# CITY OF ALBUQUERQUE

Re: KABQ Cargo Facility
3730 Spirit Dr. SE
30-Day Temporary Certificate of Occupancy
Transportation Development Final Inspection
Architect's Stamp dated 11-02-21 (P15-D004)
Certification dated 10-21-22

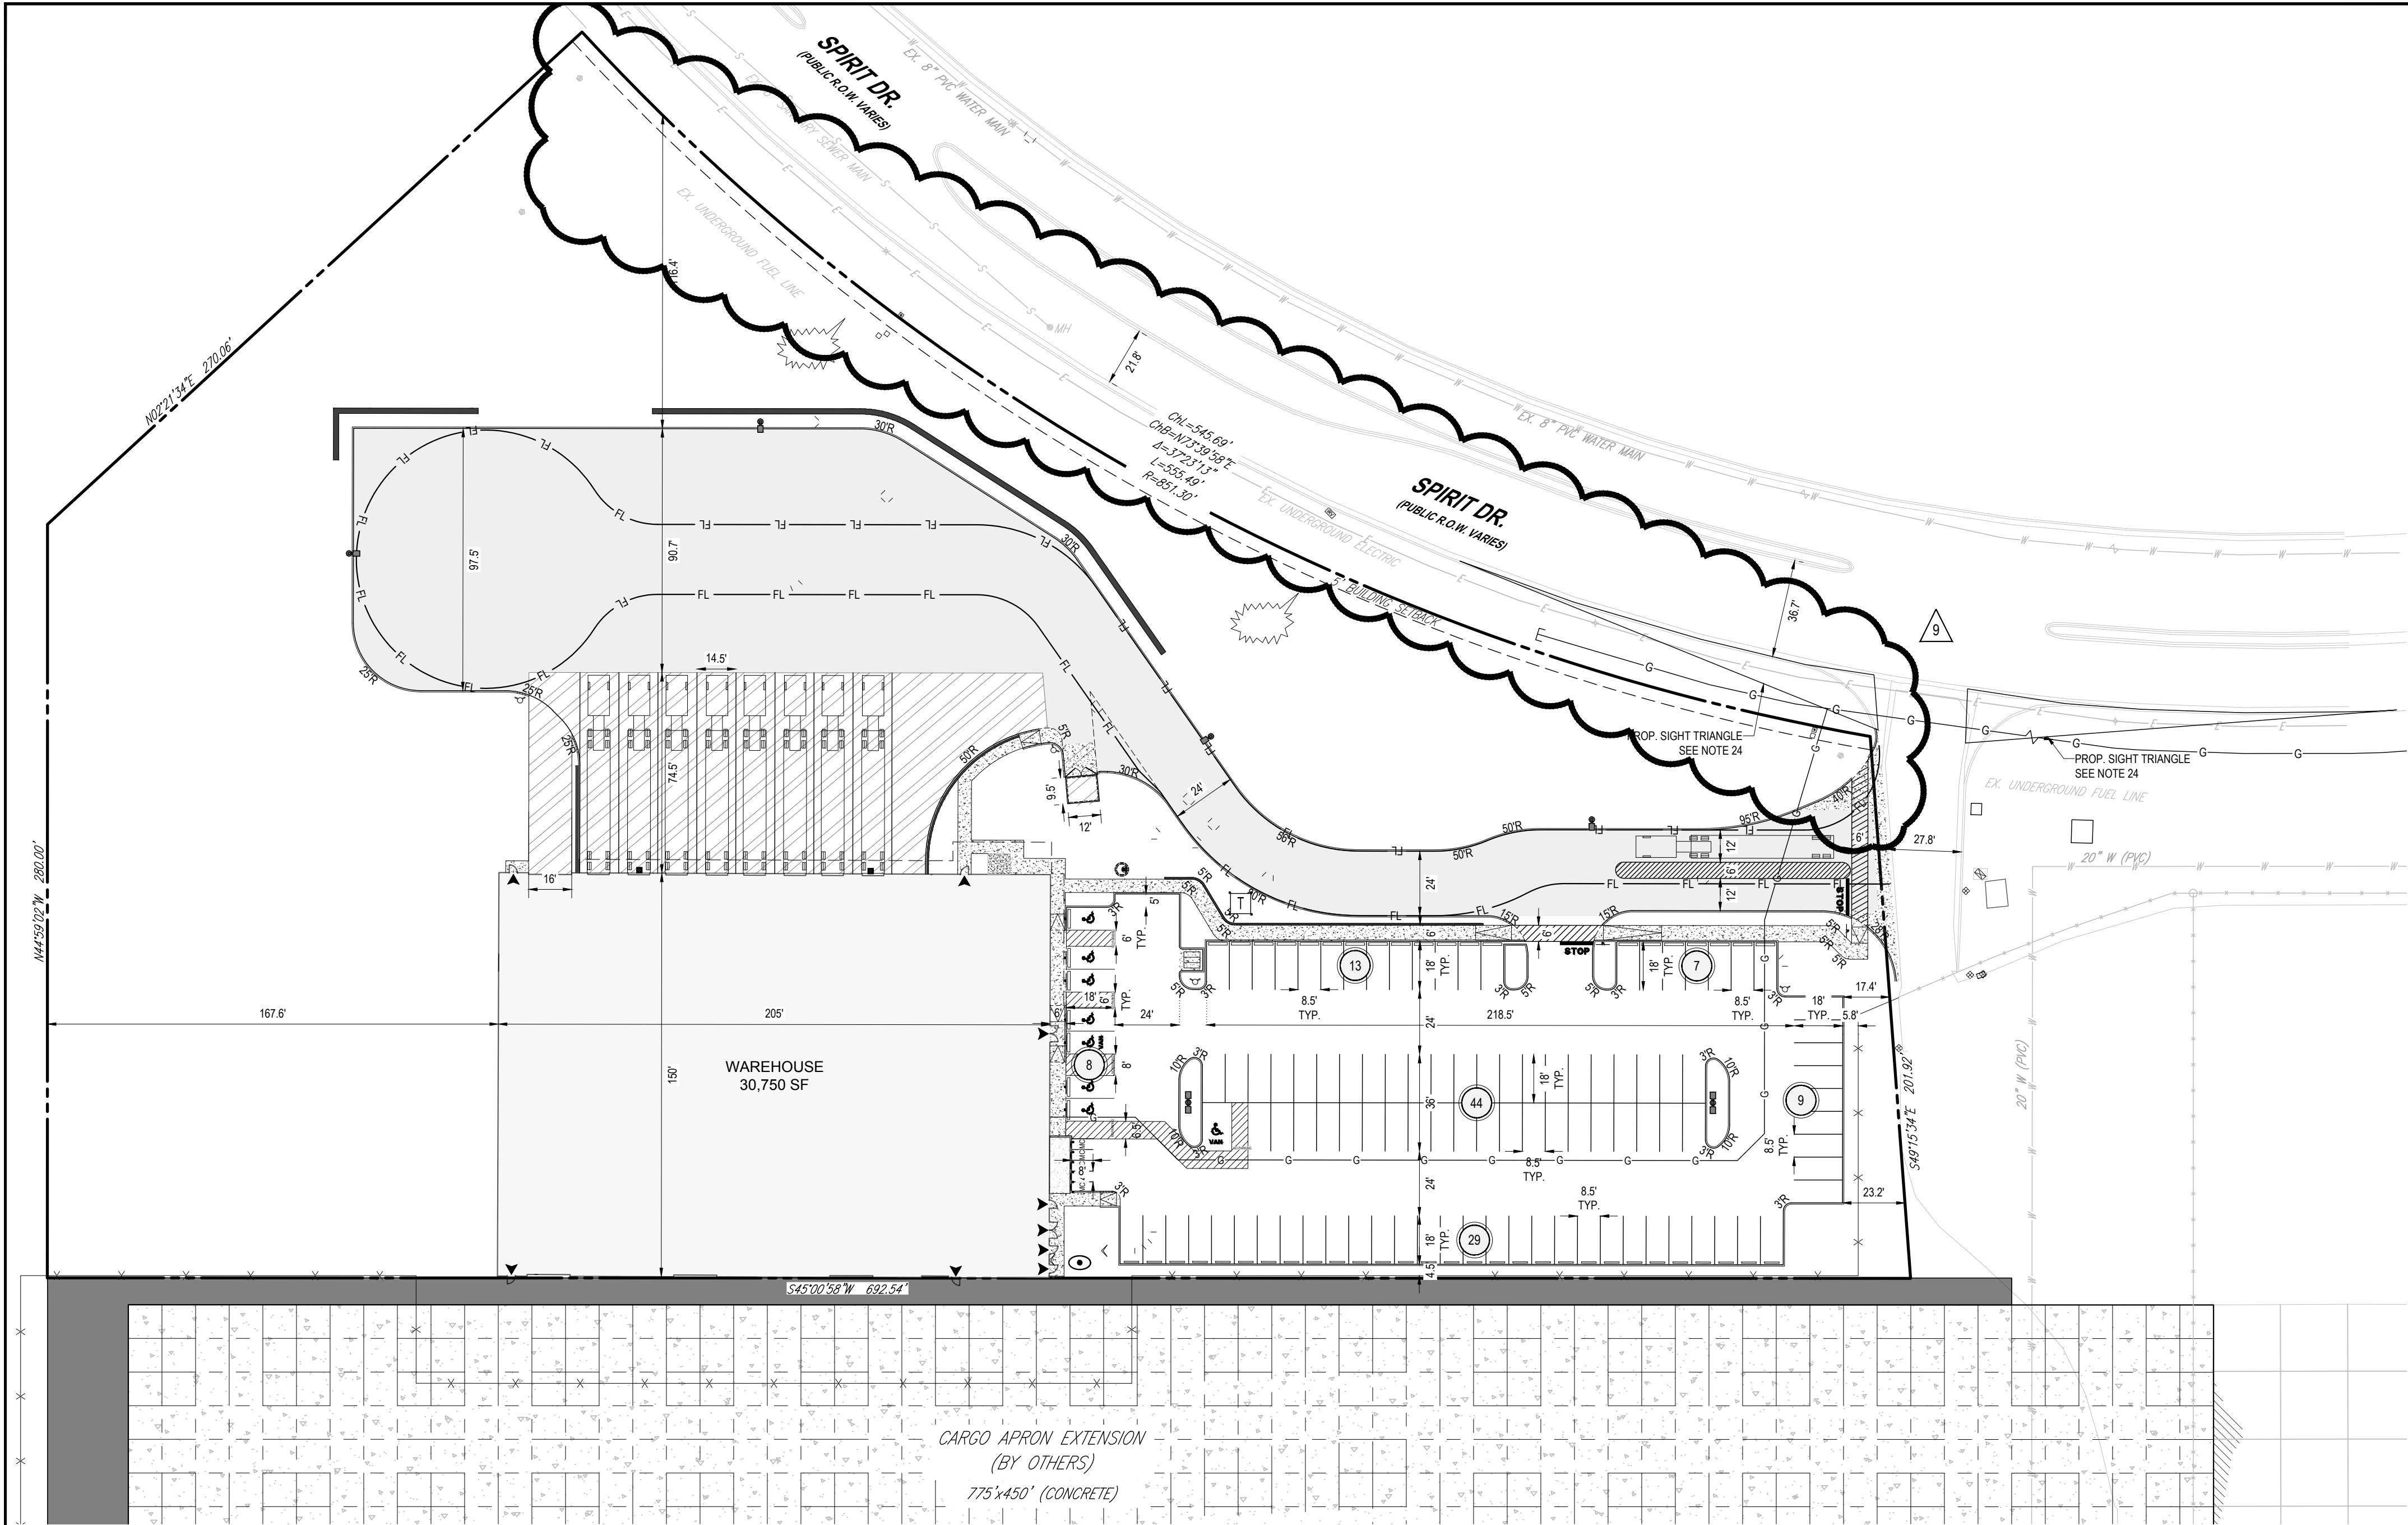
Per approved plans, the first ADA aisle located at the north east of the building is 6 ft. wide, but per site visit it is 3.5 ft. wide. Per requirement ADA aisle foe the ADA parking space other than van should be minimum 5 ft. wide.

- Please installed the ADA van sign at the ADA van parking space.
- Please provide ADA van sign at the ADA parking space adjacent to the parking island.
- ADA pathway at the north side of the parking spaces should have handrail when it is above the ground level by 6 in. or more.
- ADA ramp at the north west of the parking area access has a lip greater than ¼ in. please shave it for smooth transition. See attached picture.
